DRB Application No.: 09DRB-70101 Project # 1007008  
Project Name: Graceland Acres Addn.  
Agent: Darren Sowell Architects Phone No.:

**DRB Comments**

**PROJECT # 1007008**

**Date:** Feb. 2, 2009  
**To:** Jack Cloud, DRB Chair  
**From:** Carol Toffaleti, Staff Planner, Development Review, 924-3345  
**cc:** Craig Calvert, DSA Architects  
**Subject:** Project #1007008 – JLM Auto Sales at Candelaria/Arno  
07EPC-40104 Zone Map Amendment, 08EPC-40086 Site Development  
Plan for Building Permit

**1 SITE PLAN - PHASE 1**  
 NOTE: VEHICLES SALES LOT WITH OFFSITE OFFICE.  
 1" = 20'

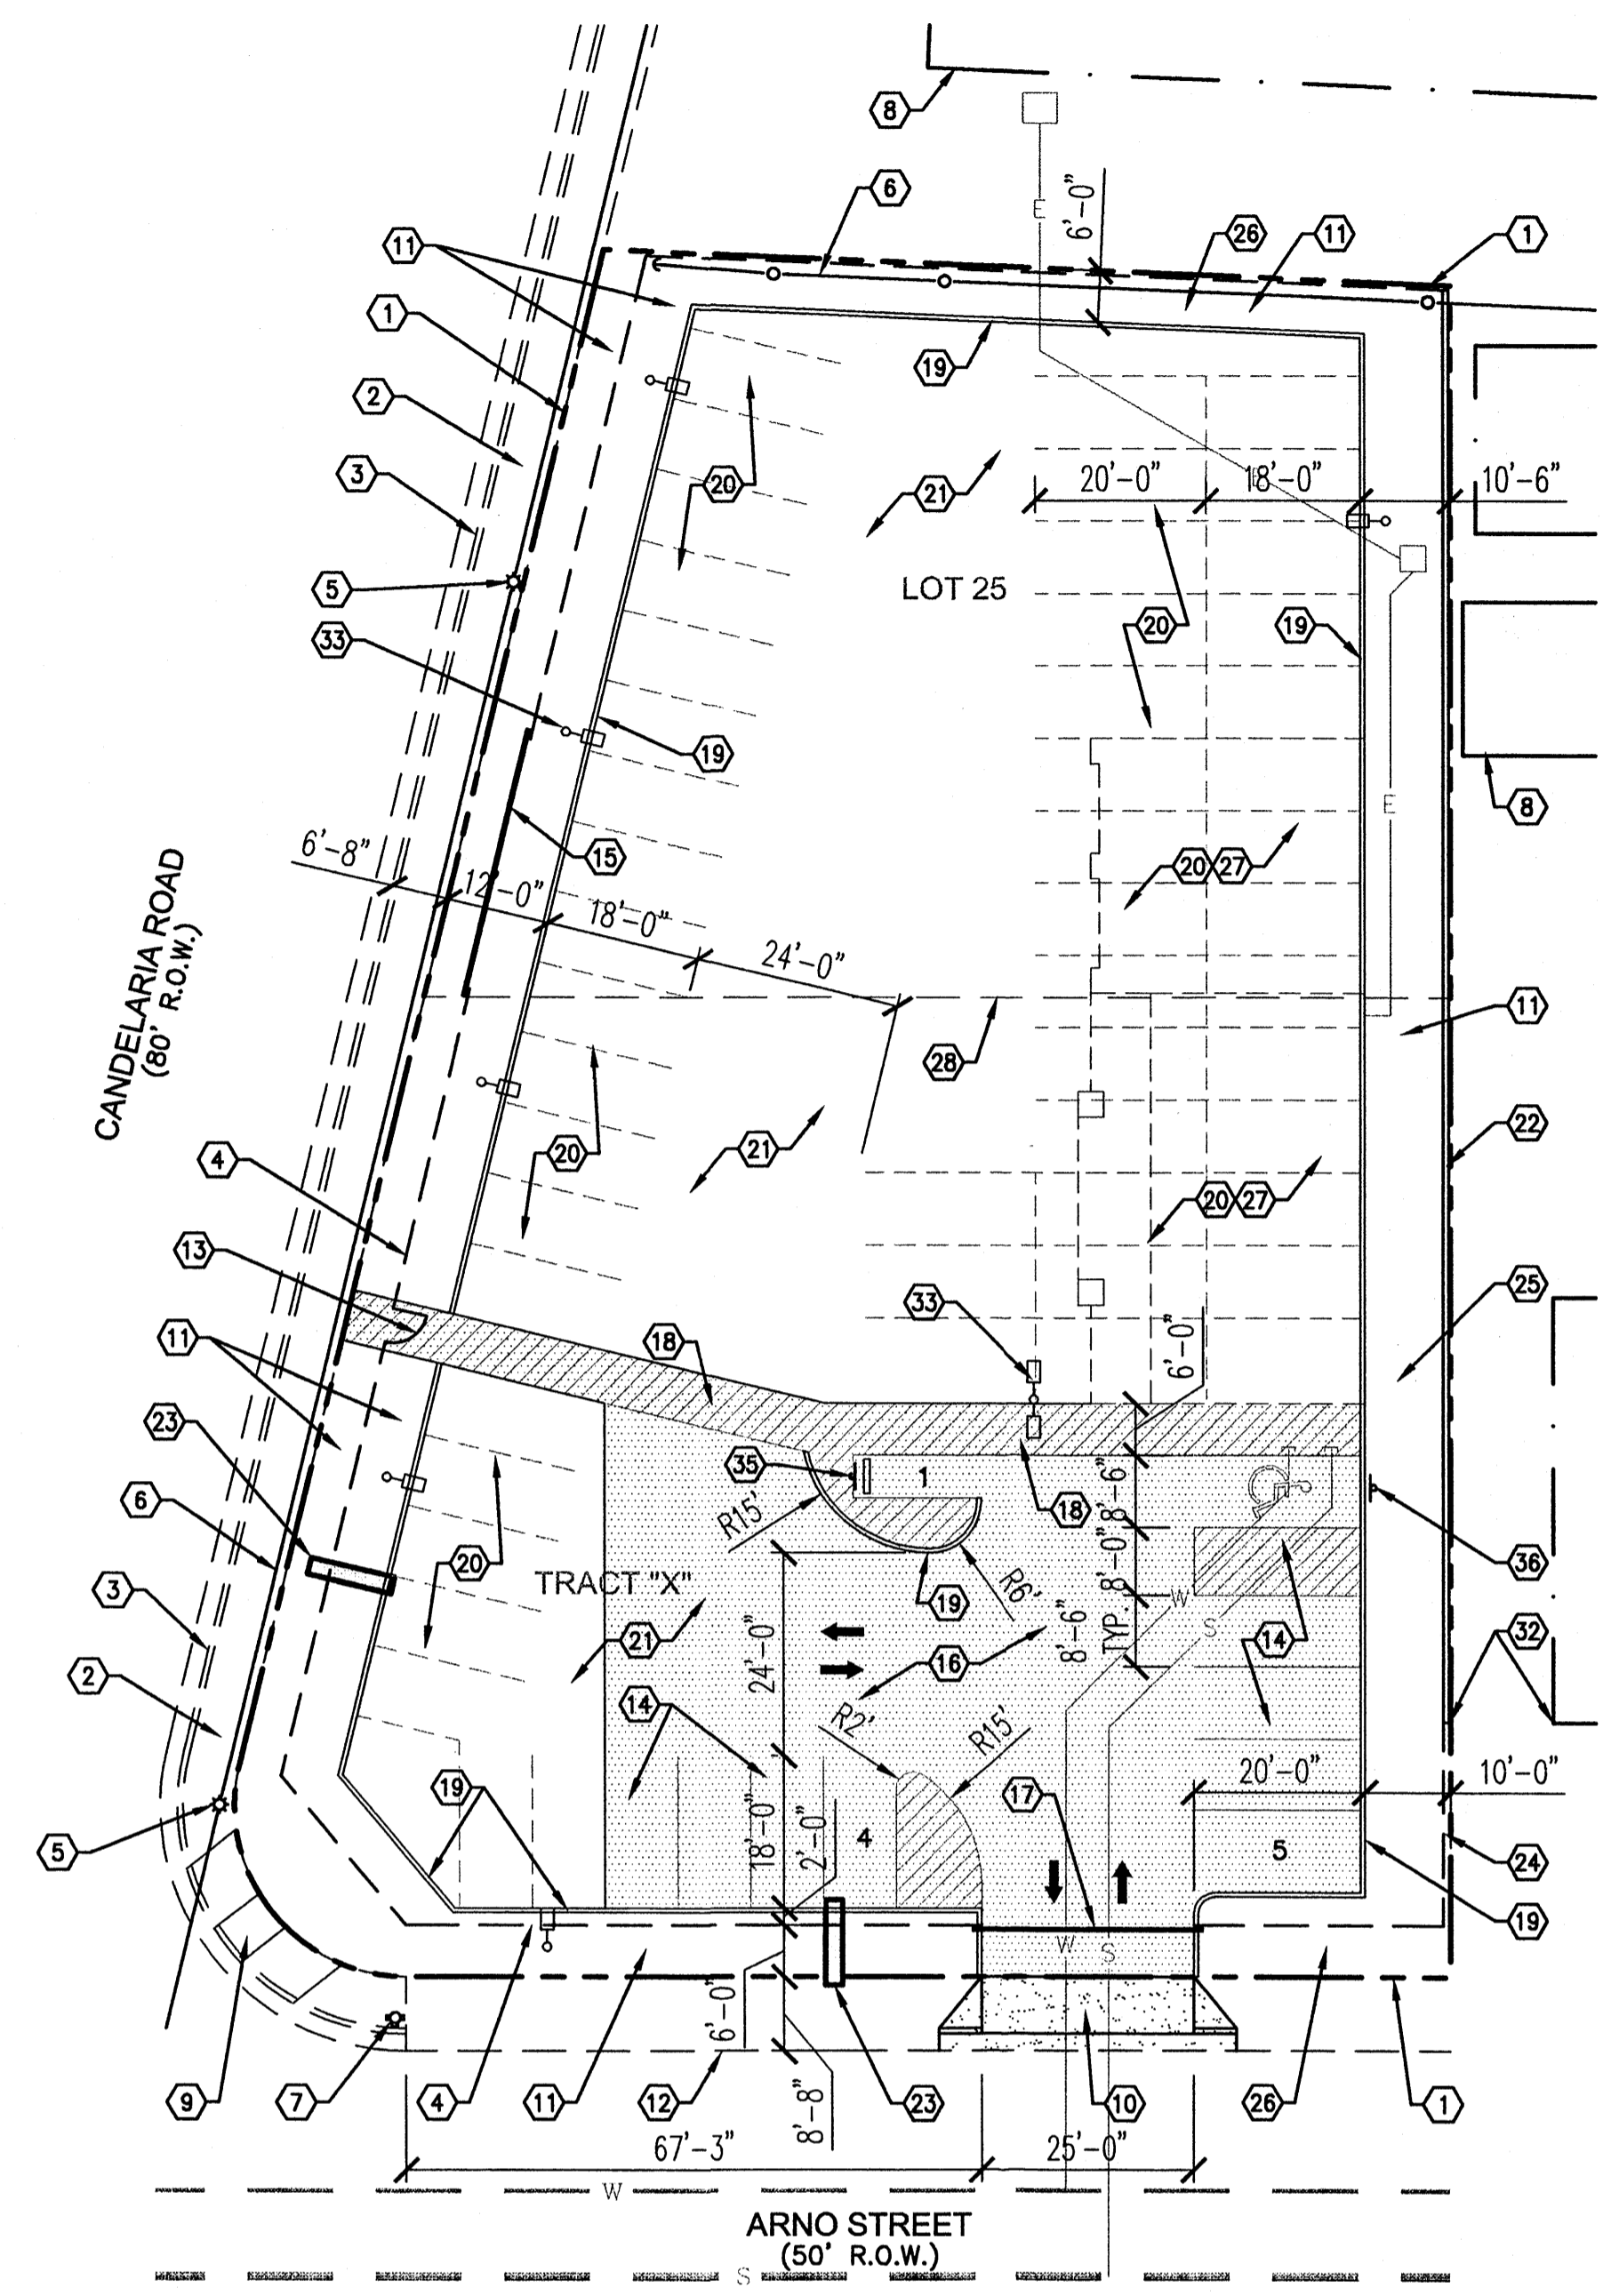
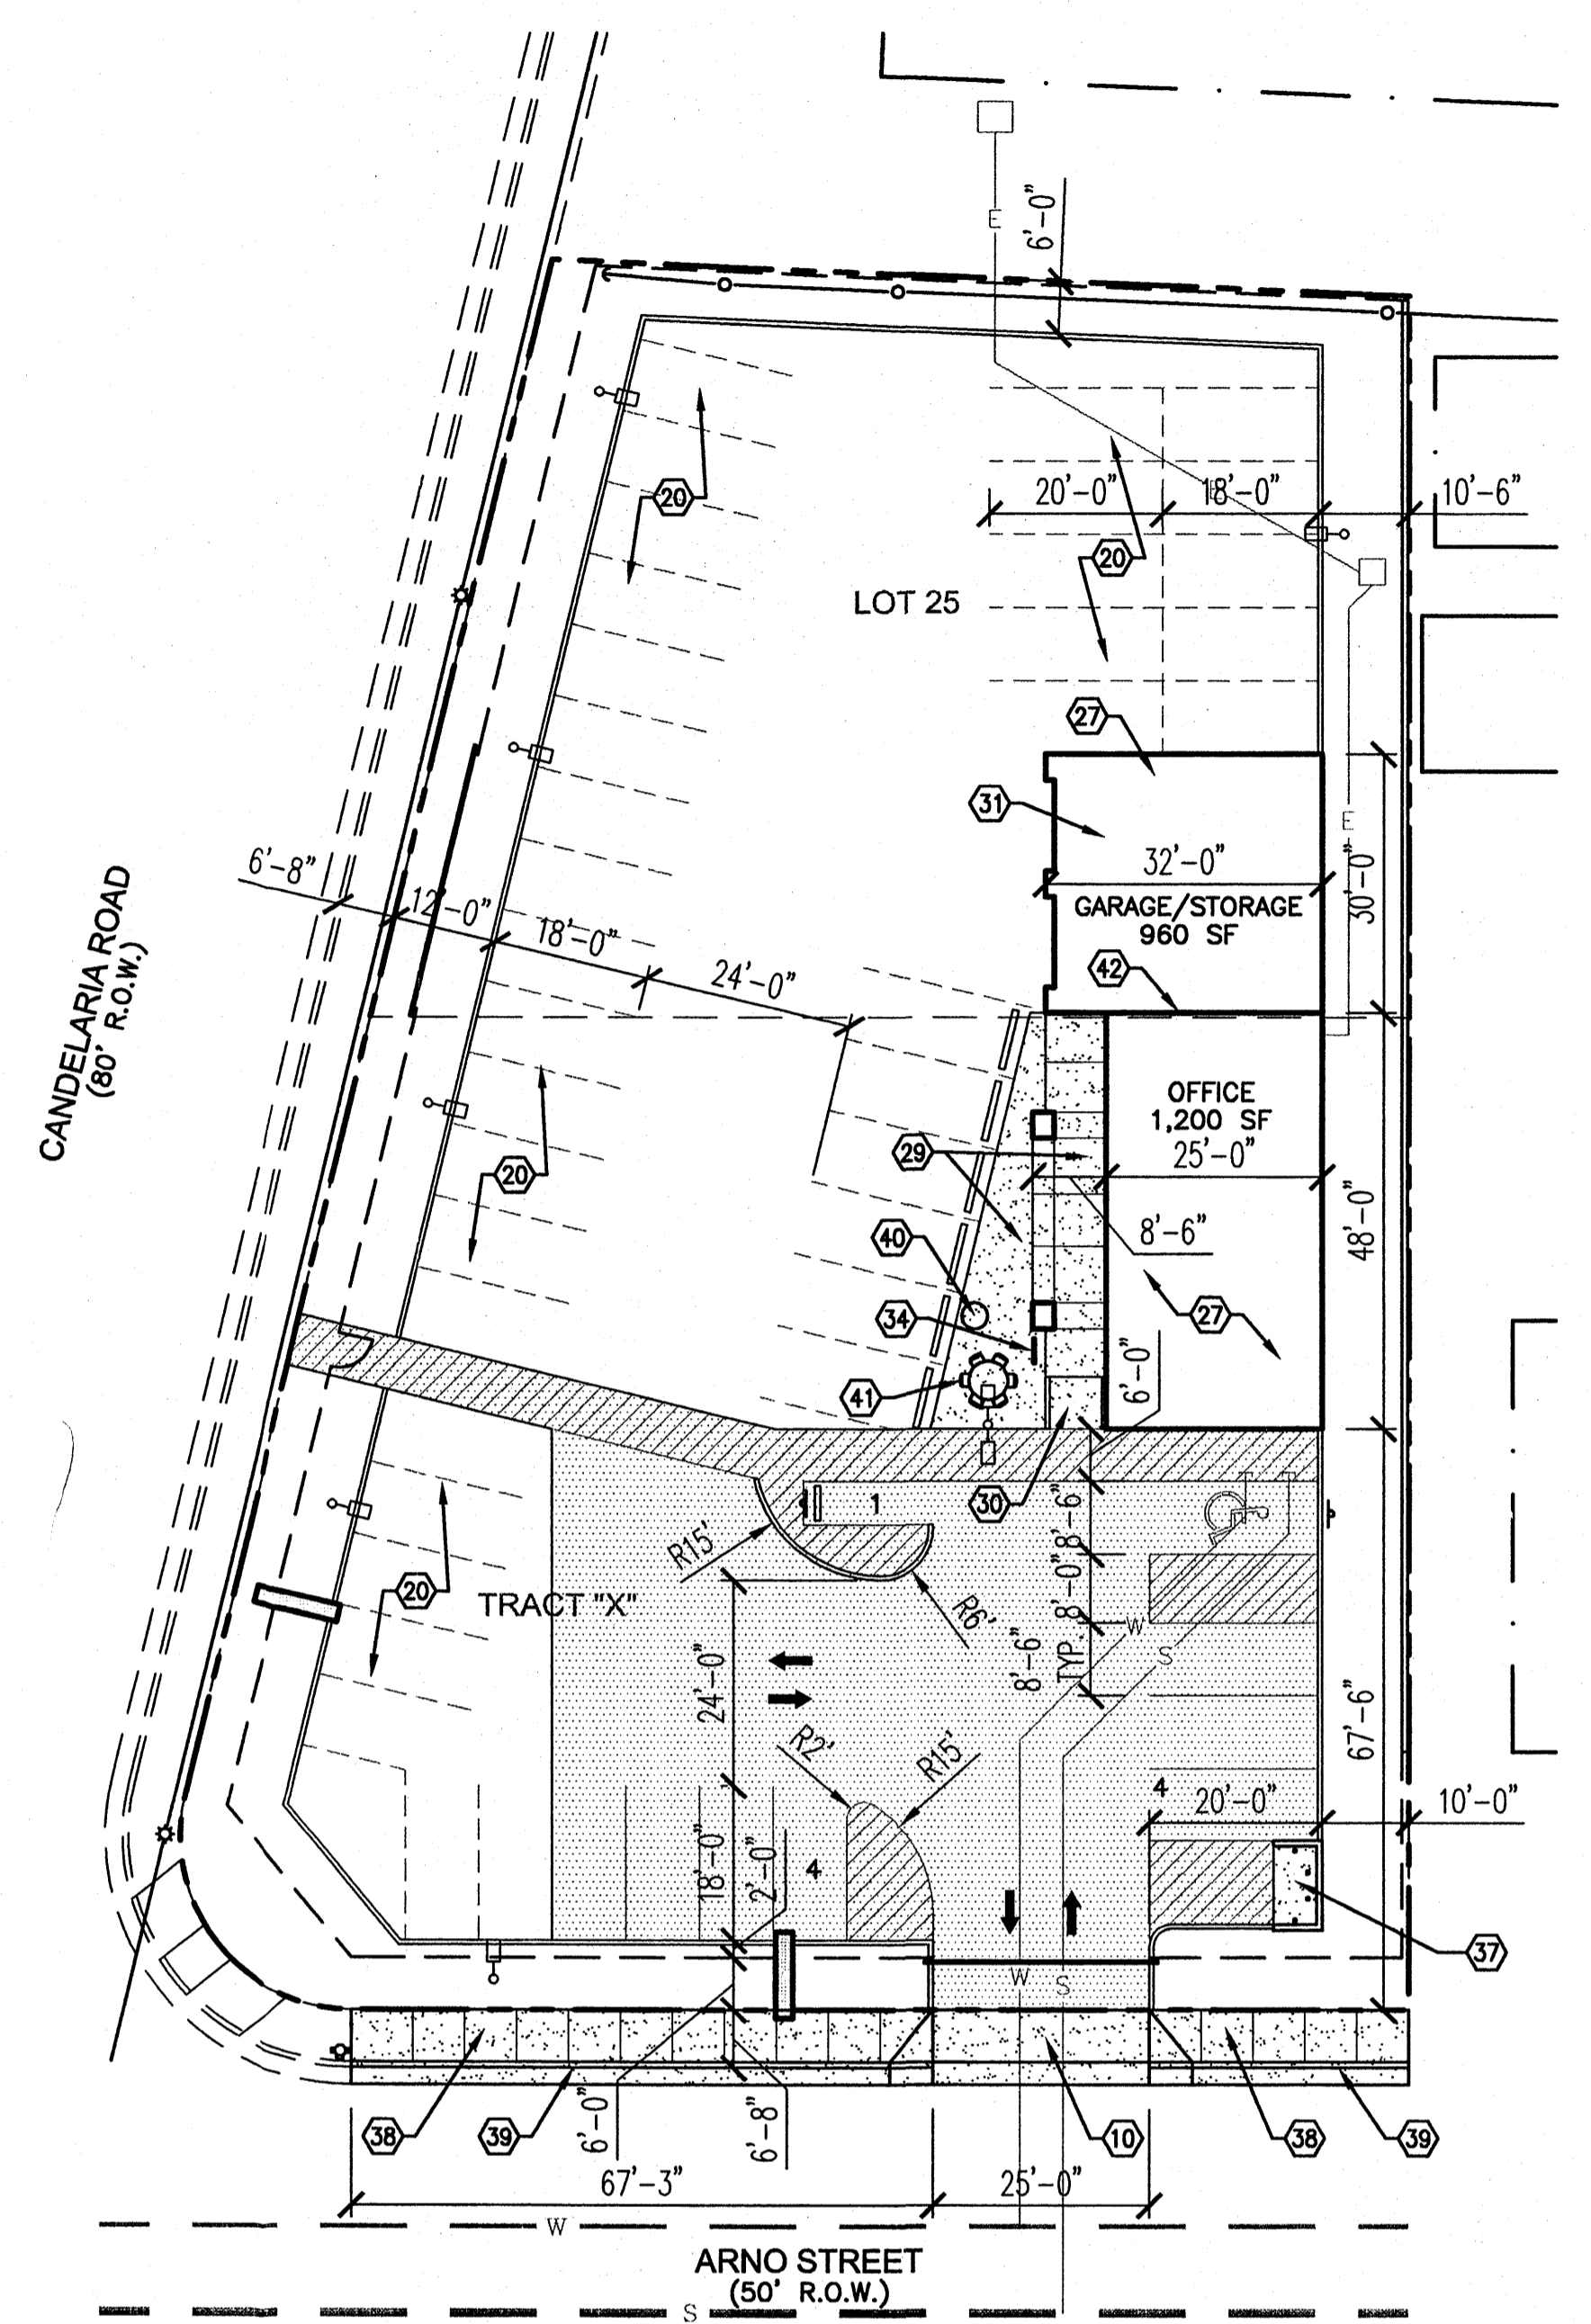
- b. Re. Dumpster location in Phase II – The proposed location will create a 6 ft high obstruction that does not accommodate the neighboring residential property-owner. The dumpster must be relocated outside the 24 ft long area between the northeast corner of the fence line and the start of the 6 ft high screen wall.

Condition 9: Correct parking calculations to indicate 9 spaces provided in Phase I.
